6 April 2016

**Response to Submissions – State Significant Development 6820, Proposed Light Weight Aggregate Facility
780 Wallgrove Road, Horsley Park**

Table 1: Response Matrix

TITLE: PRODUCT RECLAIM SYSTEM LIGHTWEIGHT AGGREGATE FACILITY			
DRAWING #: BW-AGG-100-04			
DRAWN: SAS	DATE: 08.02.16	REV: A	
SHEET: 1 of 1	SIZE: A1	SCALE: 1:300

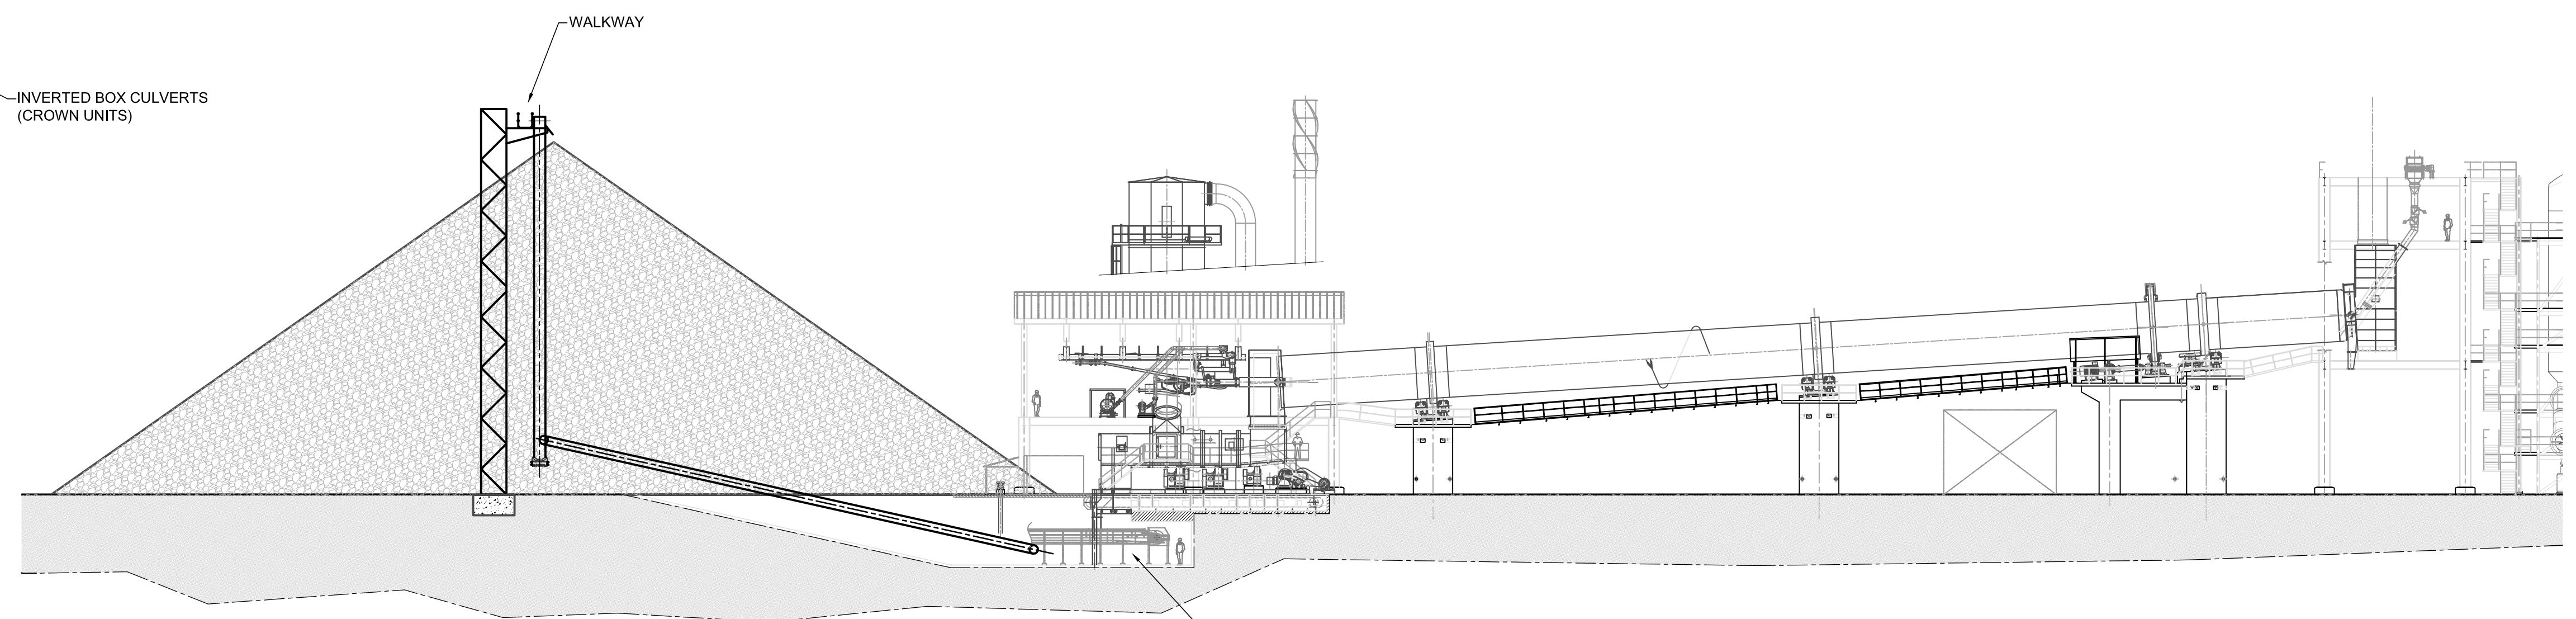
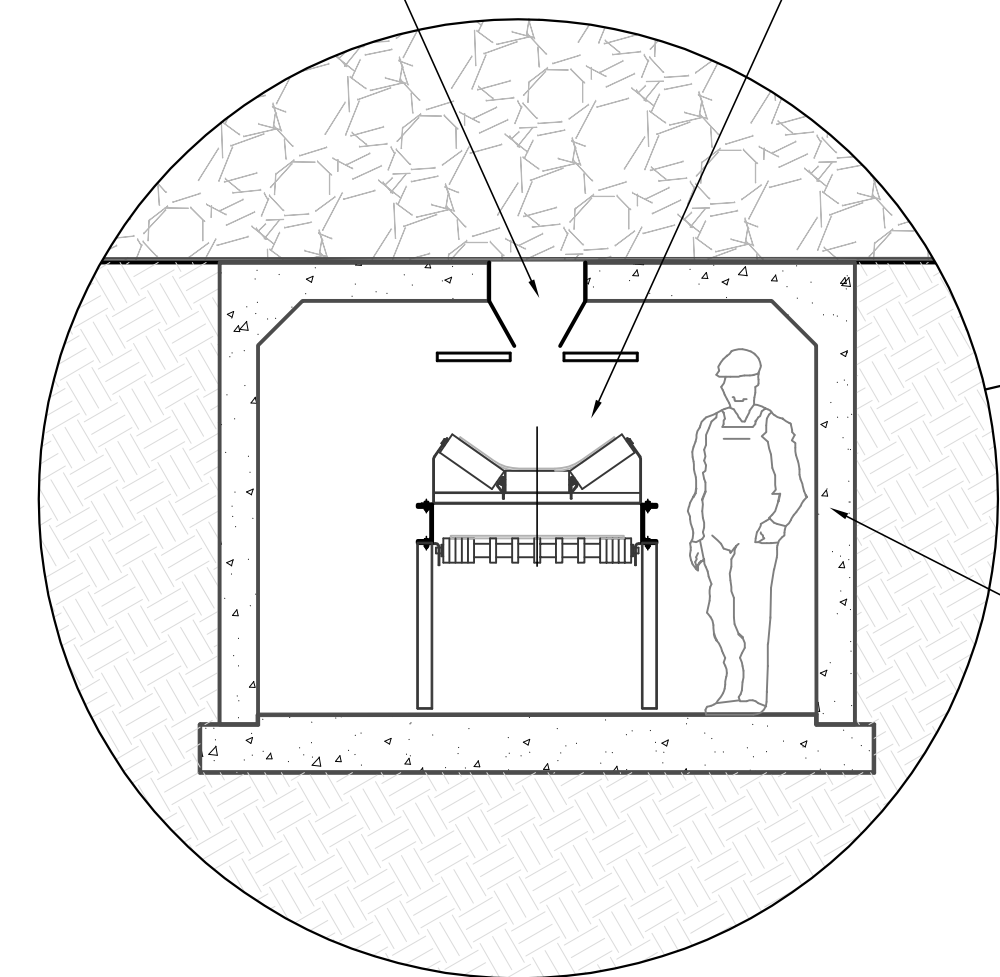
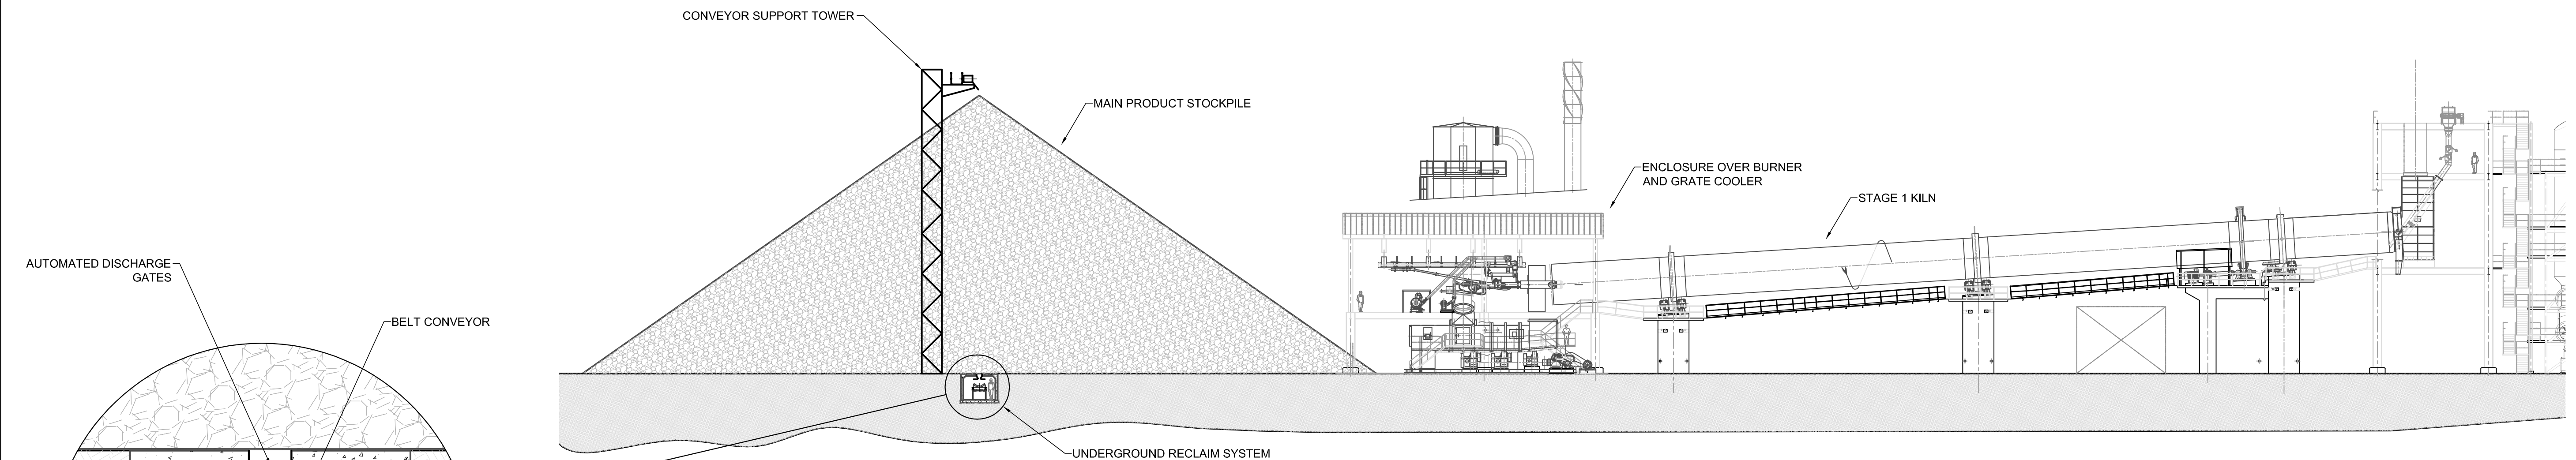
16.	<p><i>A detailed and labelled diagram of the Light Weight Aggregate (LWA) Plant is requested to provide an understanding of key LWA infrastructure including the proposed multi-fuel burner, rotary kilns and cooling air stack.</i></p> <p><i>Please explain the interaction between existing Brickworks infrastructure and the proposed development.</i></p> <p><i>It is unclear how the underground conveyor works, how deep it is and where it fits within the development footprint.</i></p>	<p>A revised process flow diagram is attached at Appendix D of the revised Air Quality Impact Assessment prepared by Airlabs dated February 2016.</p> <p>The proposed Light Weight Aggregate plant is a stand-alone process, apart from receiving processed raw materials from the existing Grinding Building that is adjacent to Ferrers Rd on the east of the site. These raw materials will be supplied to the lightweight aggregate plant by belt conveyor.</p> <p>Services to the lightweight aggregate plant, such as electricity, water, natural gas, fire and septic systems will be independent from the existing operations on the Horsley Park site.</p> <p>A diagram is included at Appendix 6 which shows a section of the underground reclaim section. The depth of this area is approximately 3m so that it can function as required.</p>
